FINAL GRADING AND EROSION CONTROL PLANS
FALCON MEADOWS AT BENT GRASS FILING NO. 4
FALCON, CO 80831 - EL PASO COUNTY
CHALLENGER COMMUNITIES, LLC

PUDSP-20-005 (FALCON MEADOWS AT BENT GRASS PRELIMINARY PLAN)
SF-22-XXX (FALCON MEADOWS AT BENT GRASS FILING NO. 4)

Engineering Review
08/19/2022 2:51:35 PM
jdrice
JeffRice@elpasoco.com
(719) 520-7877
EPC Planning & Community
Development Department

SWALE CROSS SECTIONS

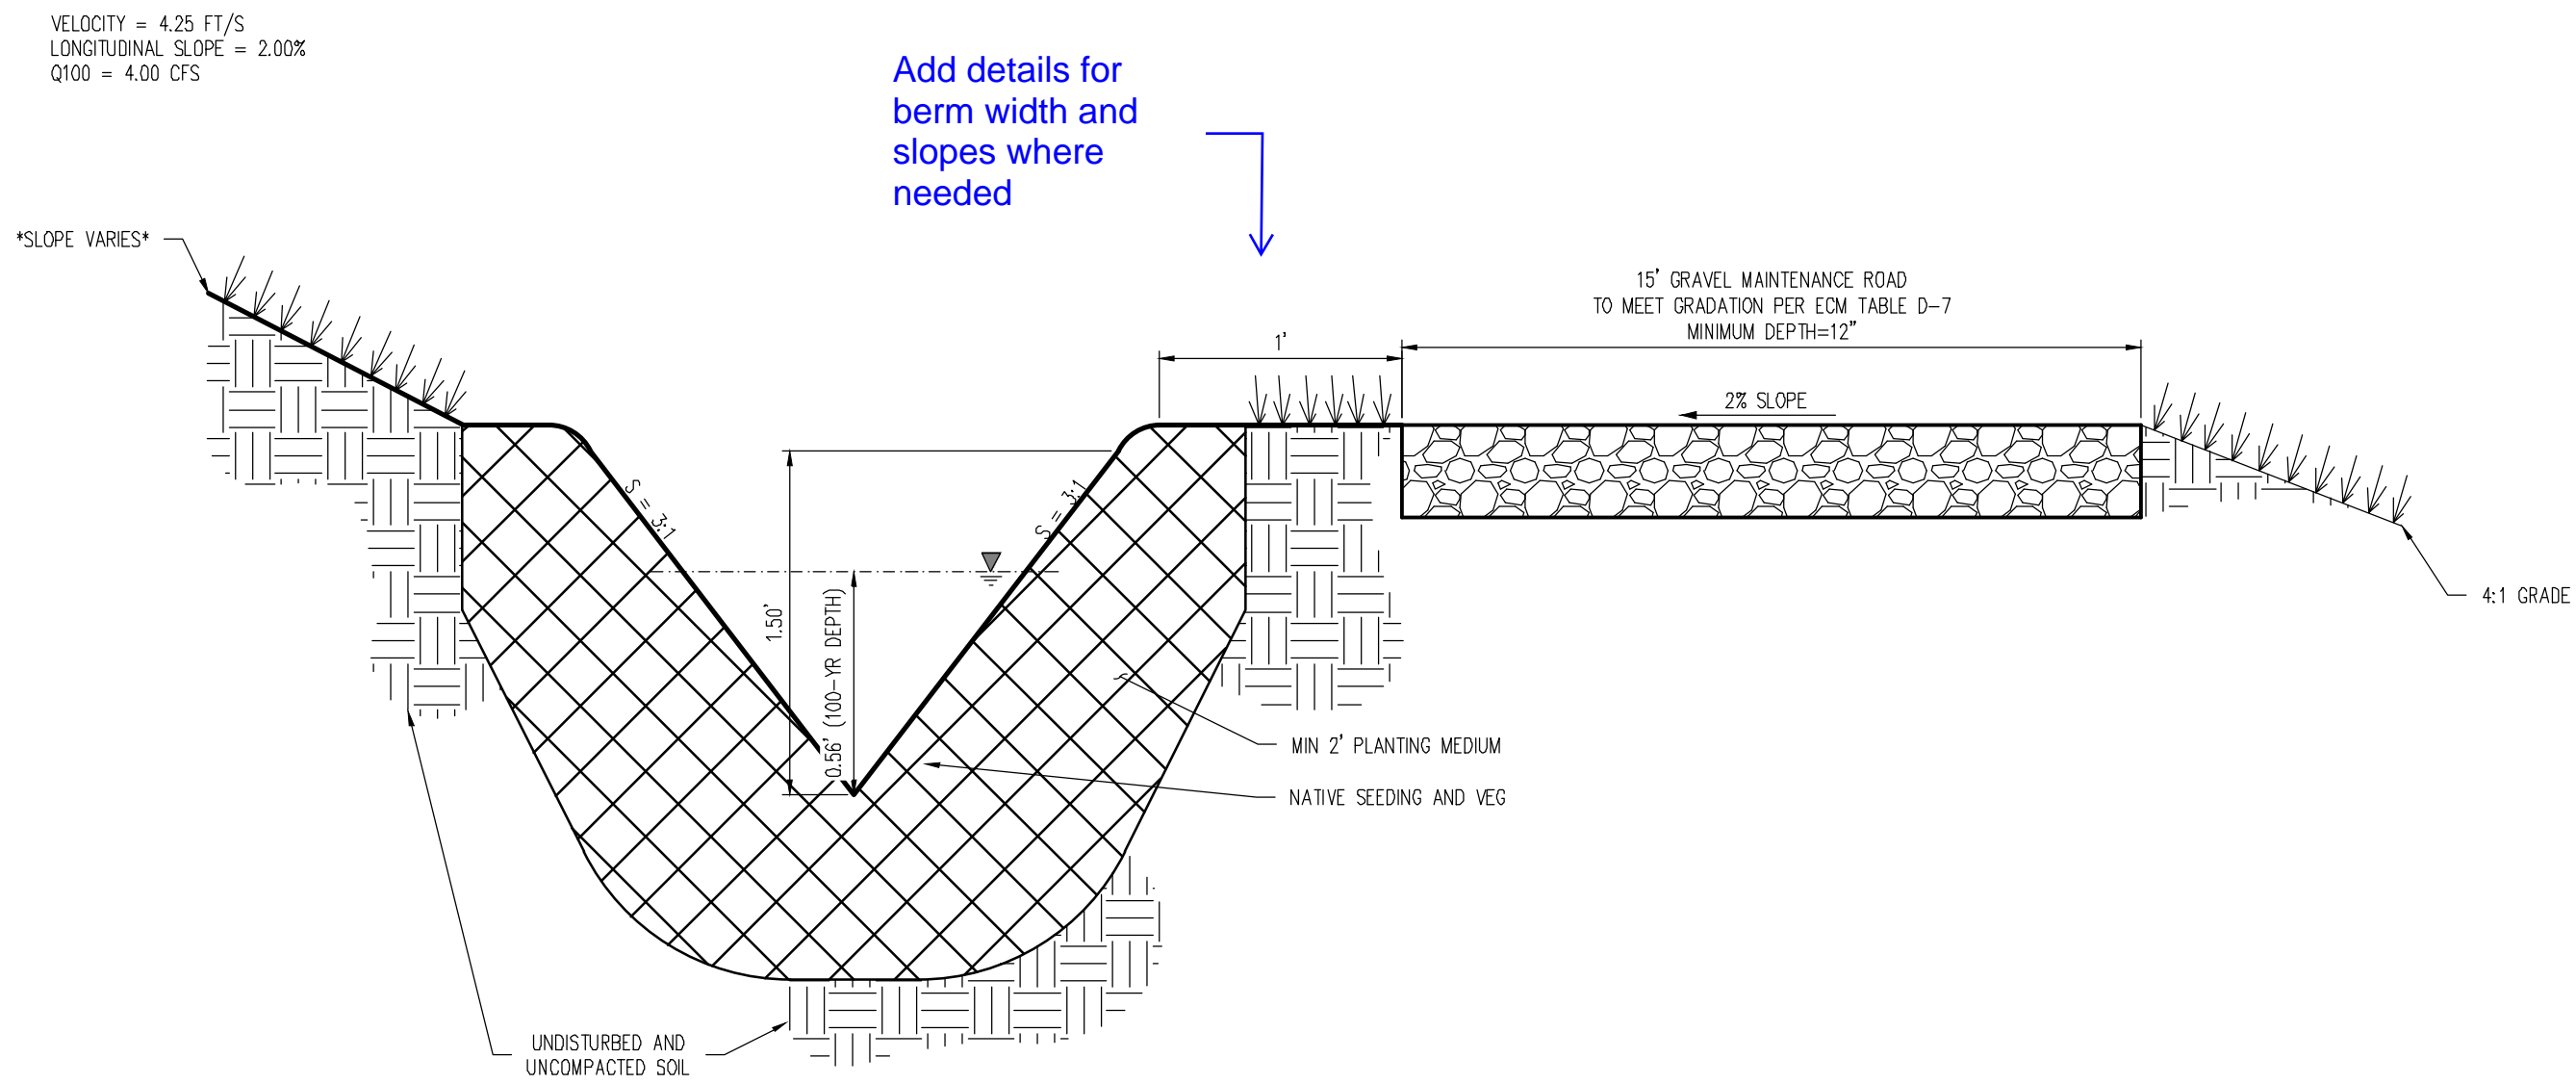
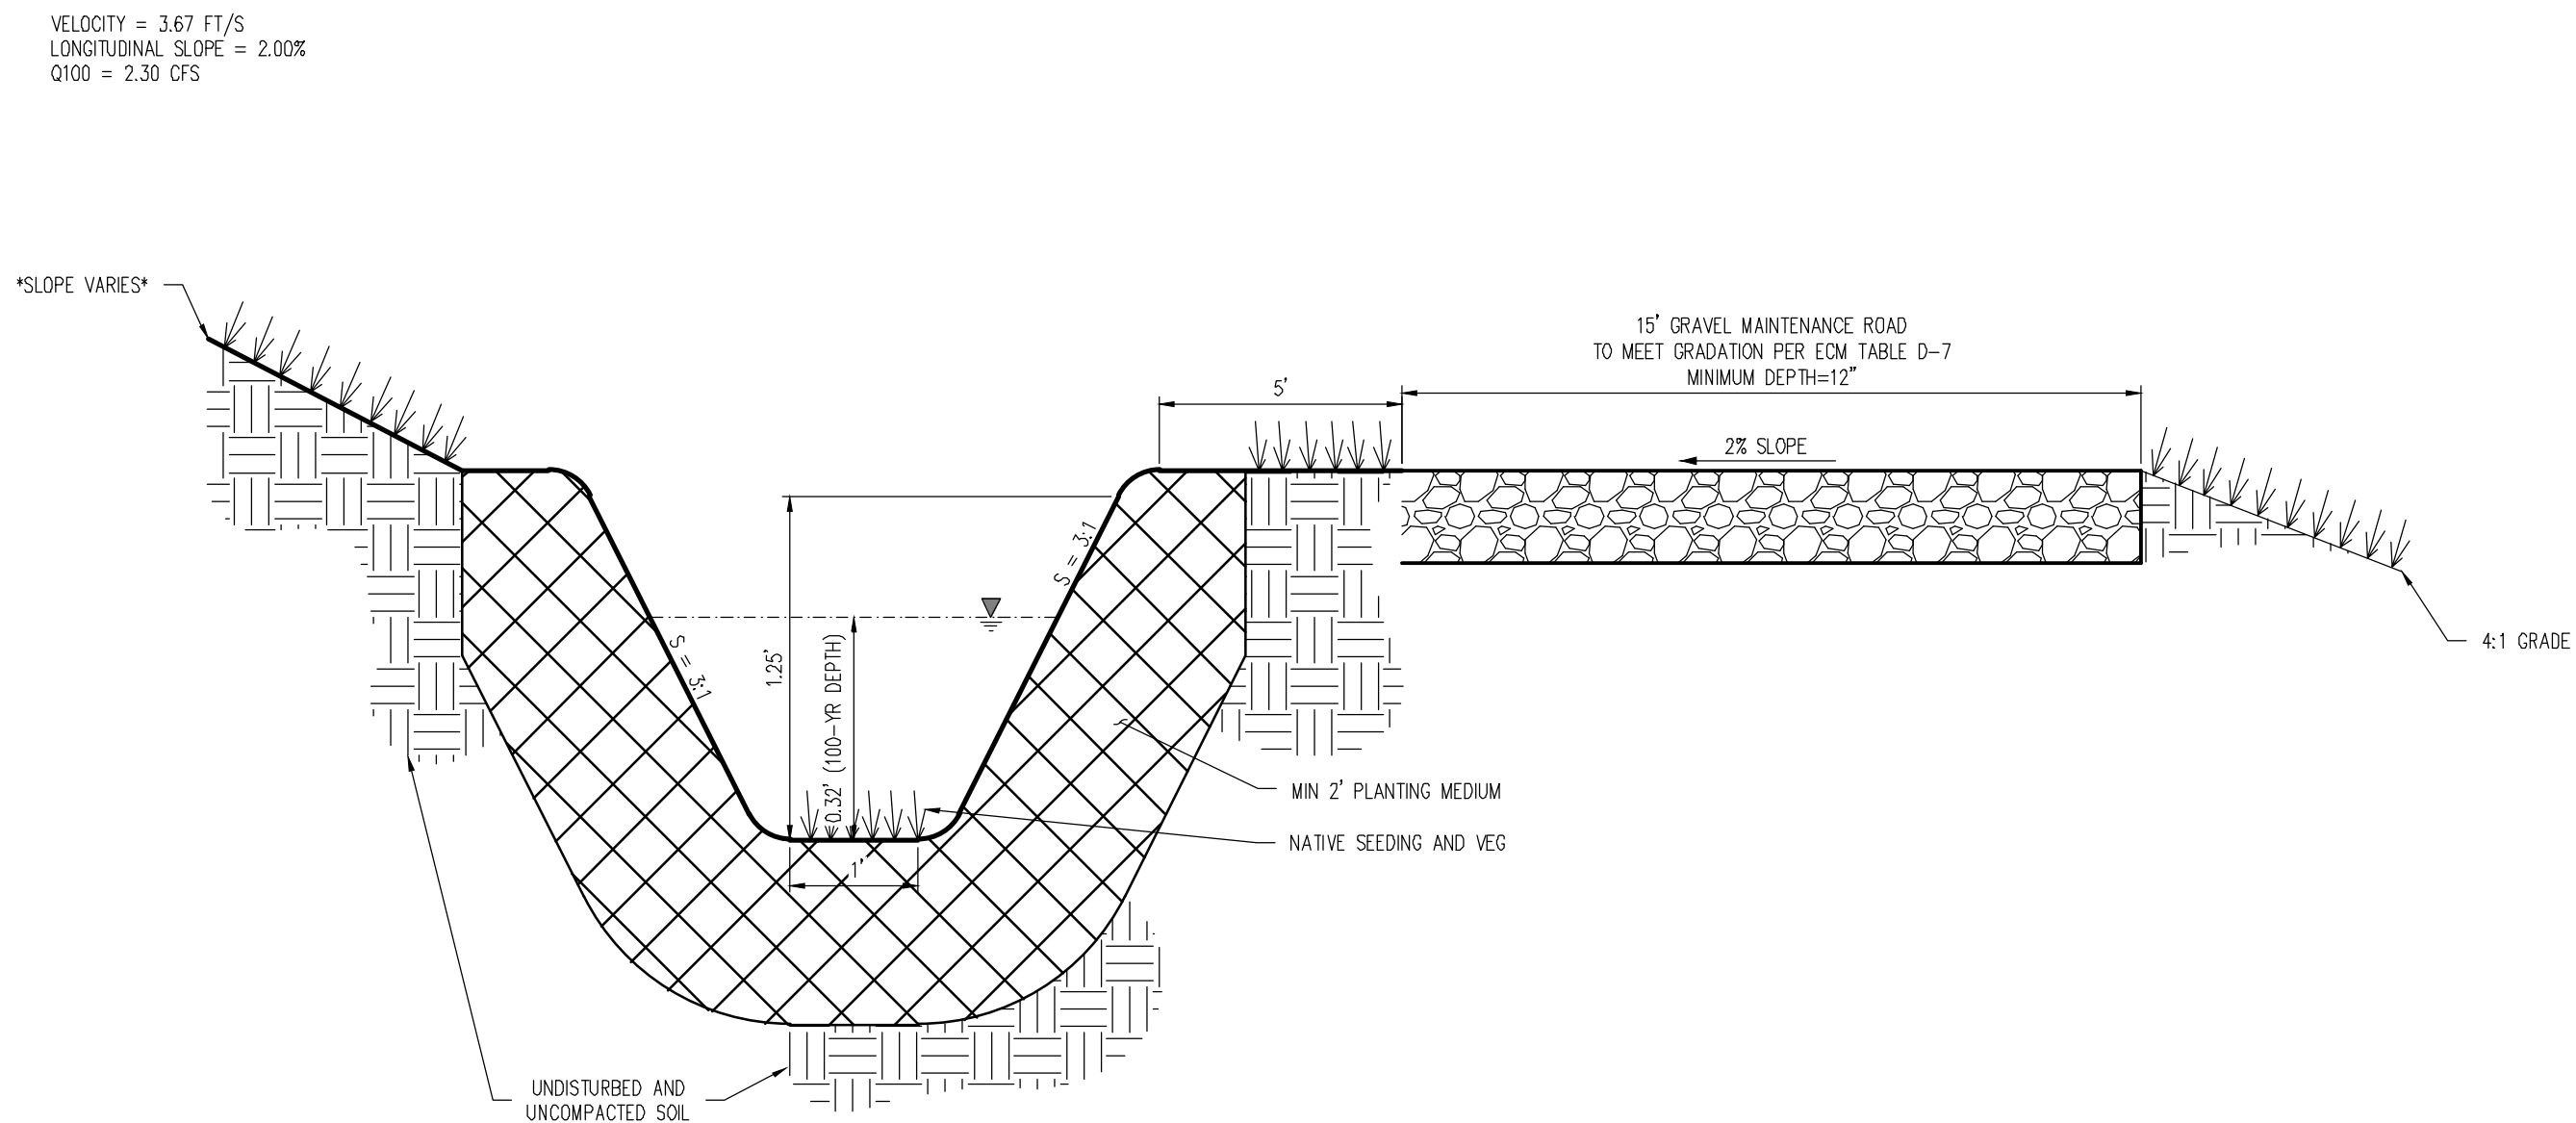
Add note referencing G4.1 for swale cross-sections
